Our ref: RA/2024/147506/02-L01
Your ref: 2024/92283

**REDEVELOPMENT OF MARKET WITH ADDITION OF MEZZANINE FLOOR –
DEWSBURY MARKET, 32 CLOTH HALL STREET, DEWSBURY, WF13 1QE**

Thank you for re-consulting us on this application following submission of a revised FRA by BDP Civil and Structural Engineering Group, referenced P3001350 Revision P03 and dated 25 November 2024, which we received on 25 November 2024.

Sketchbook 1 - FLOOD LEVELS

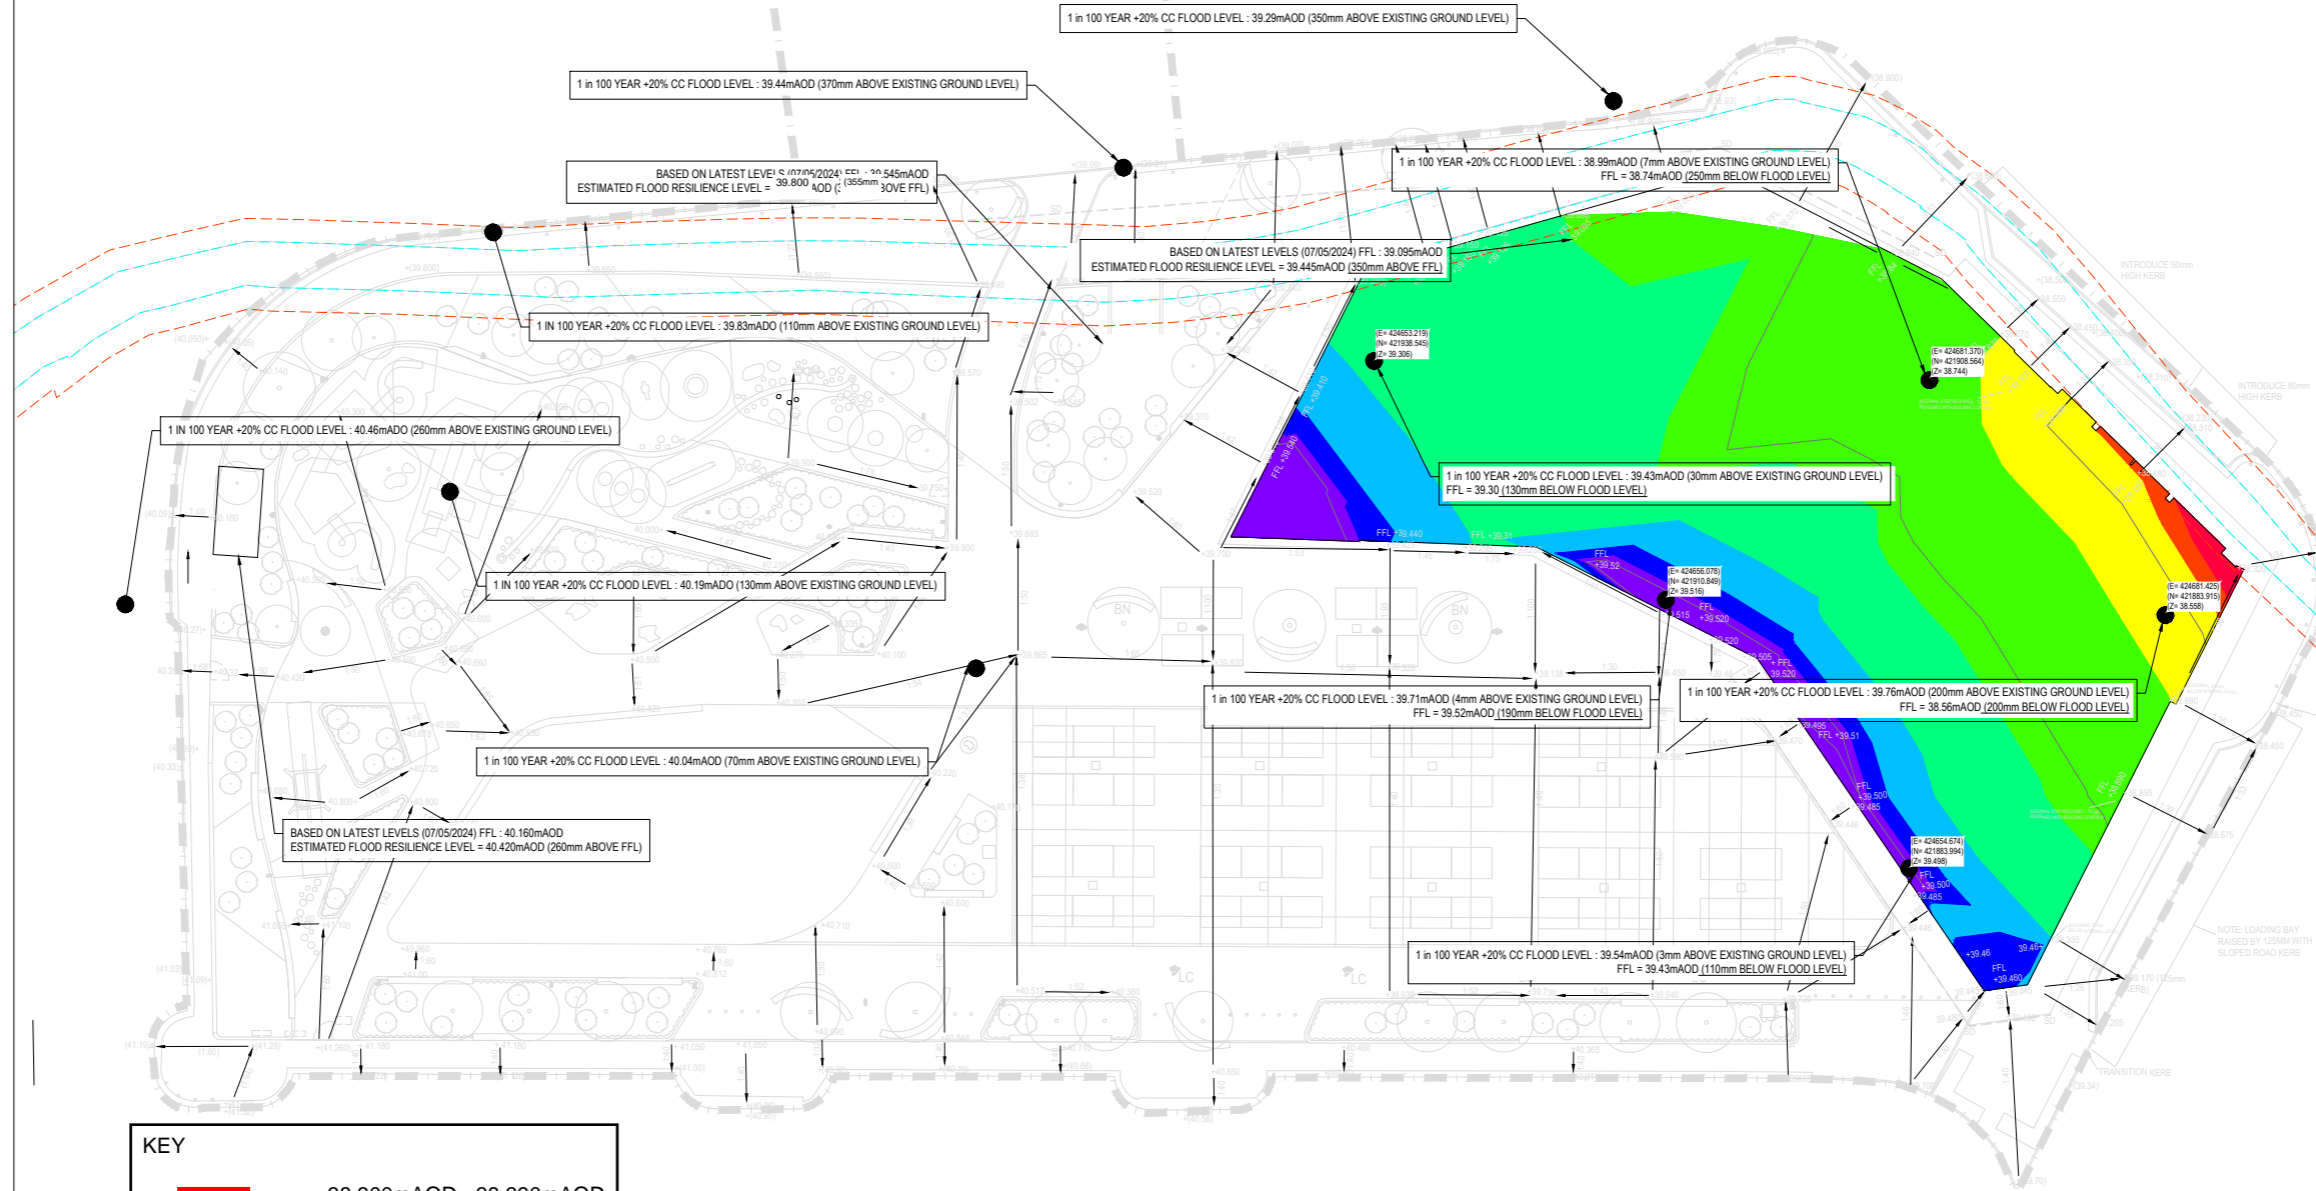
The FRA bases its compensatory storage assessment and calculations on flood zone 3a. Flood zone 3a does not consider climate change. Instead, you should use the 1% AEP plus climate change event to inform your assessment.

Additionally, it is not clear how you arrived at 22m³ increase. Furthermore, it is not clear looking at the Surface Level Data key exactly where volume is reduced and gained at different intervals of the events in metres Above Ordnance Datum (mAOD).

To overcome this, you should use contour plans of the existing and proposed topographical differences. This will enable you to display exactly where volume is reduced and gained through horizontal slices taken at vertical intervals of a flood event level (mAOD). Please present details showing where volume is reduced or gained at vertical intervals of a flood event in mAOD, as demonstrated in the examples in Figure 1 (Pre-development) & Figure 2 (Post-development) below:
